# DREHID WIND FARM AND SUBSTATION SID

## Responses to Submissions and Observations

North Kildare Wind Farm Limited

P25273-FT-XX-XX-RP-XX-0002

DETAIL A - STANDARD TRENCH ARRANGEMENT IN PUBLIC ROAD
Scale 1:10

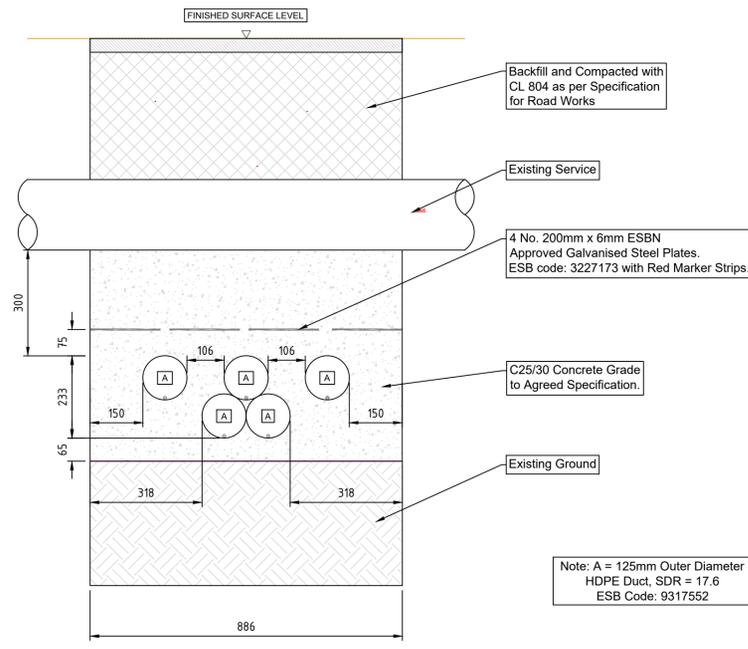
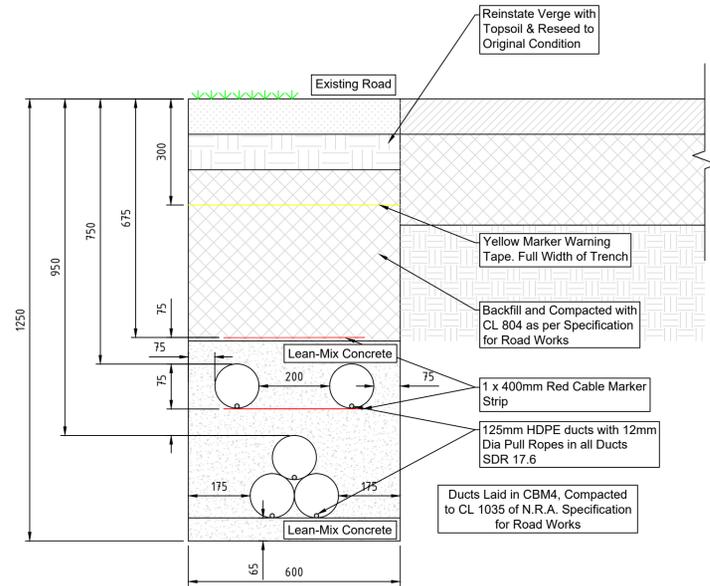
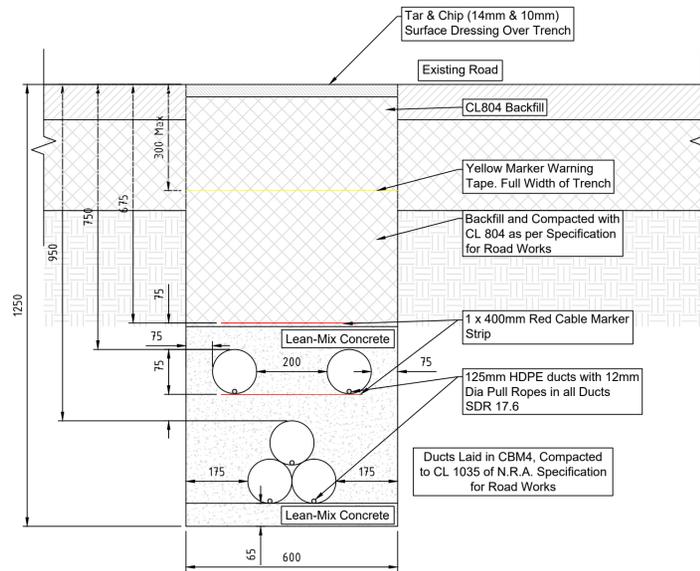
The KCC Transport, Mobility and Open Spaces Department also has concerns about the extent of cable route construction on the L50242 for proposed connection to substation. They assert that these works have the potential for serious traffic hazard and disruption in the area.

We submit, as Arup have detailed within the EIAR, that this is a small section of cable proposed over circa 1.38km of the public road L50242 required in order to connect the northern and southern turbines. It is important to note that the road works and the associated impact will move as the works progress and therefore the impact along this one stretch of road will be temporary. Traffic associated with delivery of construction materials for the cable routes has been included in the traffic figures for the overall construction as set out in Section 13.5.3 of the EIAR.
